**KIRKLEES METROPOLITAN COUNCIL
INVESTMENT & REGENERATION SERVICE**

**DELEGATED DECISION TO DETERMINE APPLICATIONS FOR
CONSENT, AGREEMENT OR APPROVAL REQUIRED BY CONDITION**

Reference No:	2023/44/93795/W
Site Address:	Land off, Wesley Avenue, Netherthong, Holmfirth, HD9 3UL
Description:	Discharge of condition 9 (construction management plan) of outline permission 2020/91146 (appeal decision APP/Z4718/W/21/3276678) for erection of residential development
Recommending Officer:	Ellie Thornhill

Officer report

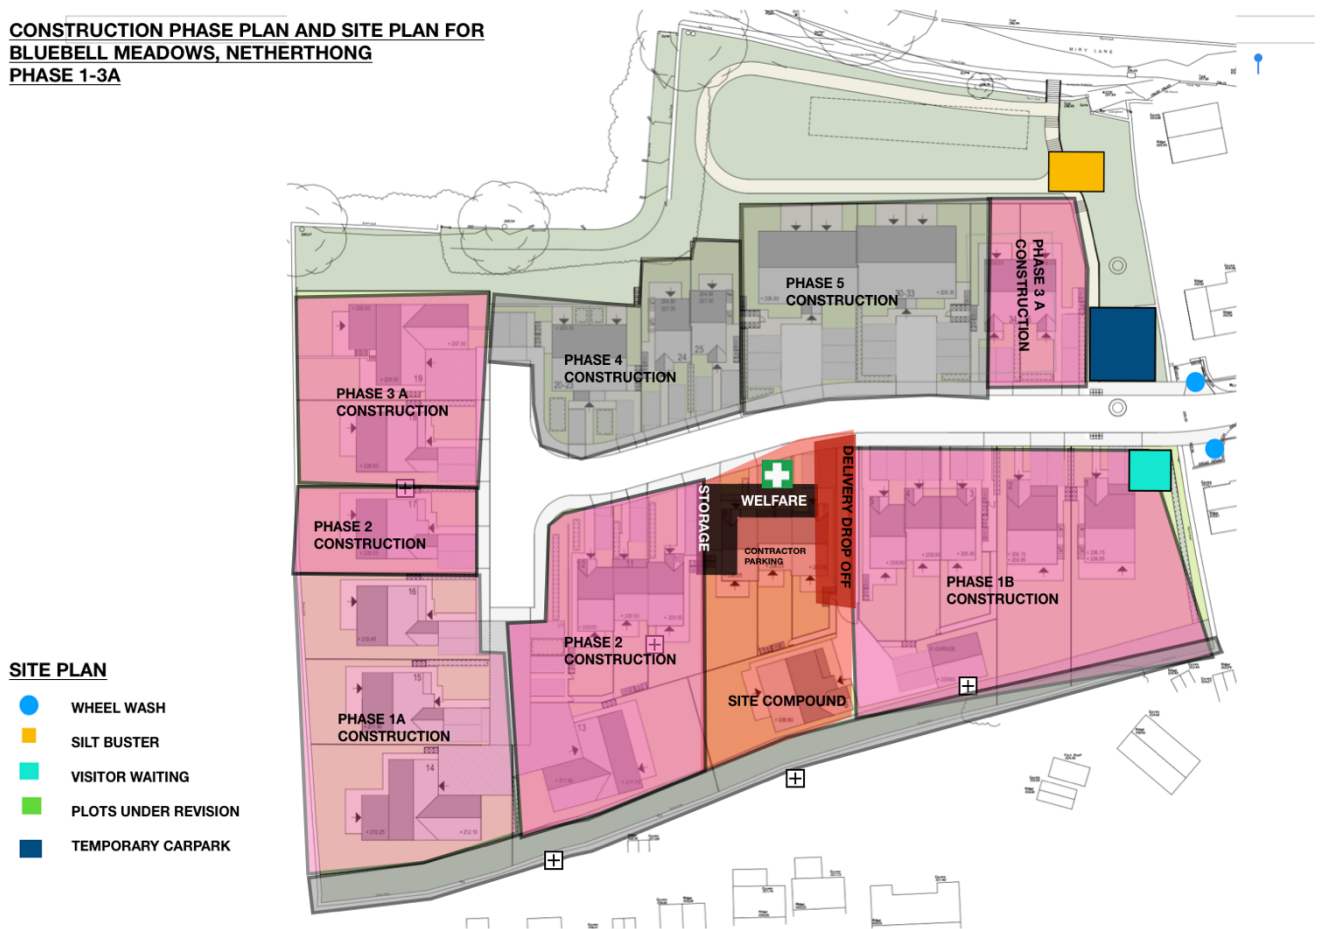
The access route for deliveries has been amended to use only suitable roads with a waiting location identified on Wilshaw Road, away from residential streets. This will include construction traffic entering the site via Dean Avenue, then on to Denham Drive and Holmdale Crescent and then turn right on to B6107 Moor Lane towards Meltham. Appropriate signage has also been proposed for the designated route.

This routing is considered acceptable in amenity and highway safety terms.

### CONSTRUCTION PHASE PLAN AND SITE PLAN FOR BLUEBELL MEADOWS, NETHERTHONG PHASE 1-3A

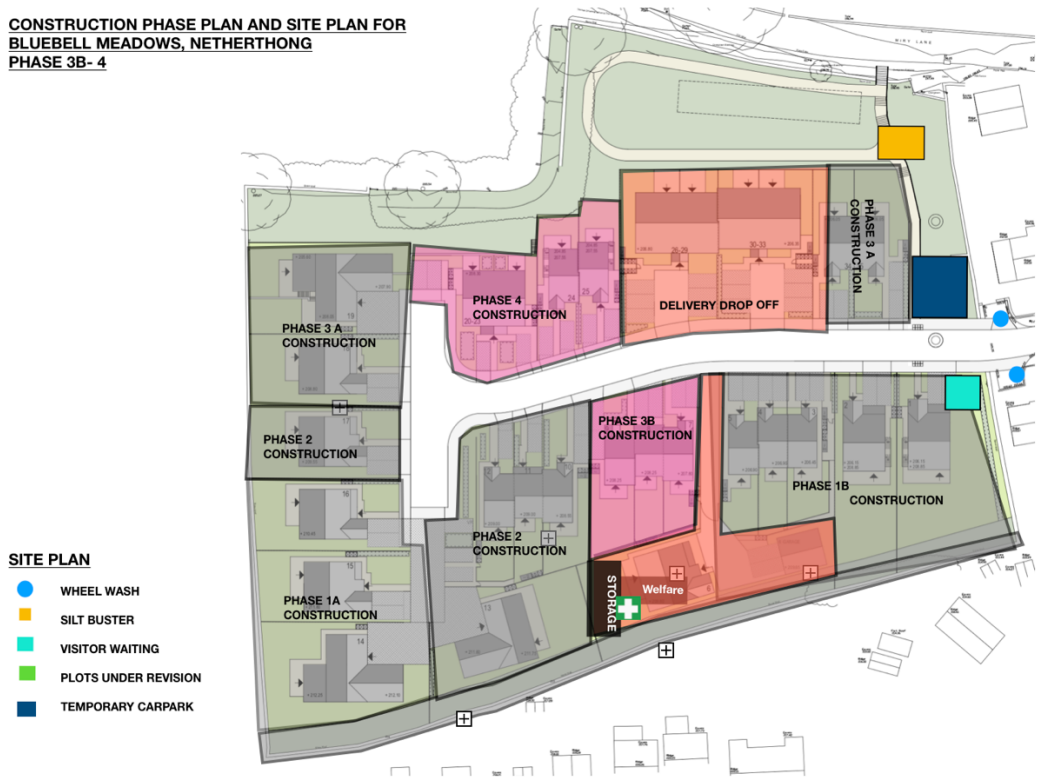
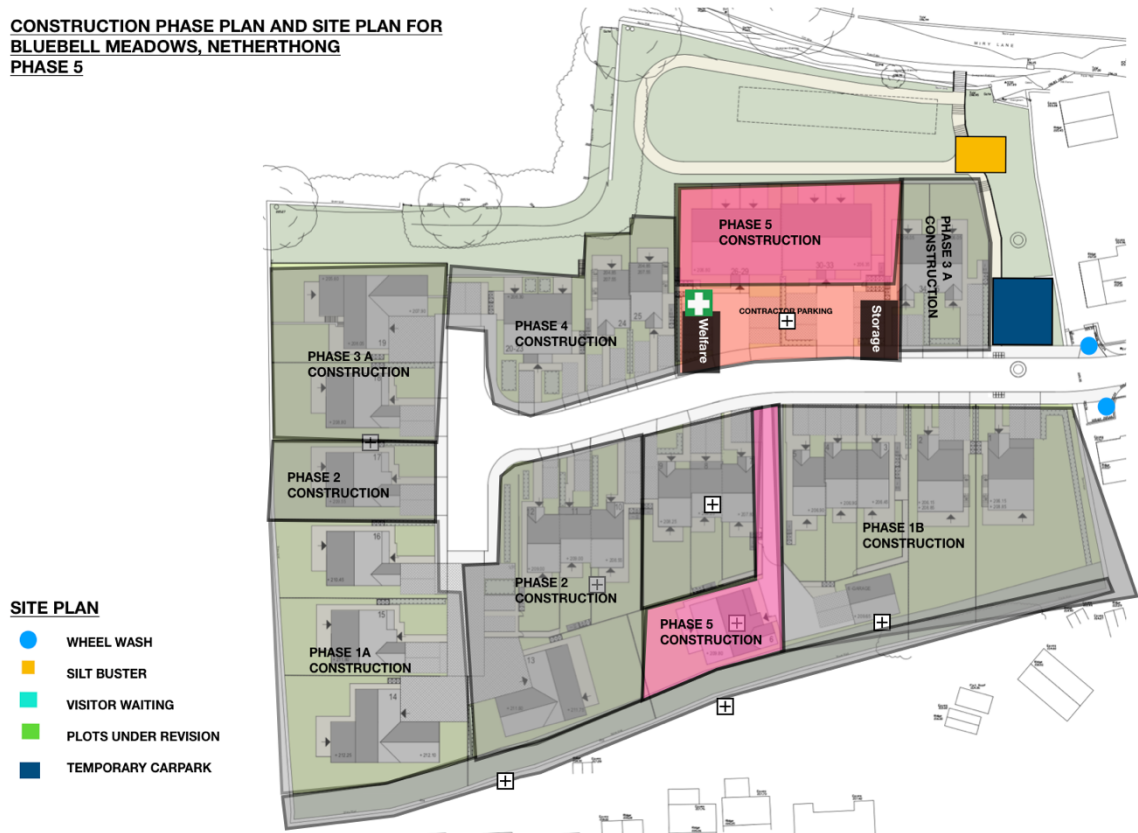
The majority of construction staff will not be on-site until the road, services, drainage, attenuation and parking are all in place. A temporary carpark will be set up as per the plan included within page 12 of the submitted document, as an initial priority, and the applicant has stated that this should be created within two working days. This will be used for all contractors that are completing the initial ground works, and therefore no site traffic will be parked on Wesley Avenue or nearby roads after this point.

The proposed arrangement for construction workers' parking are considered acceptable.

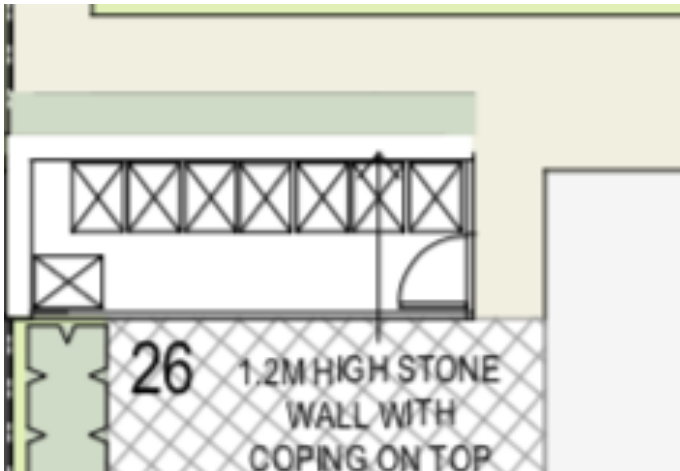
Appendix C contains the construction phase drawing and details of dust suppression and road cleaning. This states that surrounding residential estate roads will be cleaned once a week by an external contractor, however in the early stages of the construction, especially during groundworks and prior to the internal road being constructed, this may be required on a day-to-day basis based on need.
